7 May 2021

**RE: SUBMISSION IN RESPONSE TO THE EIS ON THE
PROPOSED NEW COBAR COMPLEX PROJECT (SSD-10419)**

Thank you for the opportunity to table this Submission in response to the proposed New Cobar Complex Project planned by Peak Gold Metals Pty Ltd ('PGM'), a subsidiary of Aurelia Metals Limited ('Aurelia').

Figure 6.1 **Ground vibration monitoring data and site law**

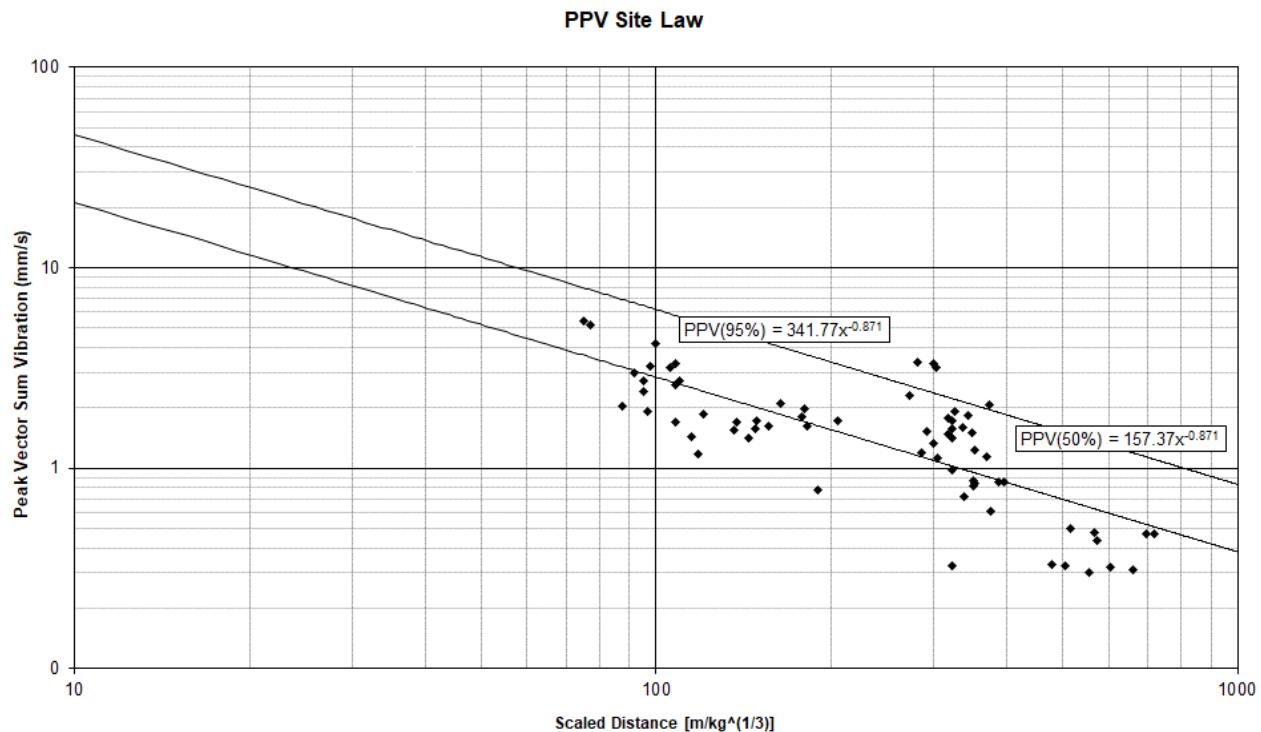
Whilst PGM currently manages the potential impacts from blast vibration at off-site receivers, the results from the NVIA and the SIA consultation reveal a disconnect in the measurement and technical standards related to blast monitoring and management, and the experiences of local stakeholders.

- conditions that limit ground vibration caused by blasting to the tightest standards reasonably possible;
- a condition for the most up-to-date blast and noise monitoring equipment to be installed and maintained at Fort Bourke Hill and adjacent to "Dellavale" to assist in the management of blast and noise impacts; and
- Data from blast monitoring be made available live and in real time on a website and recorded in future AEMRs.
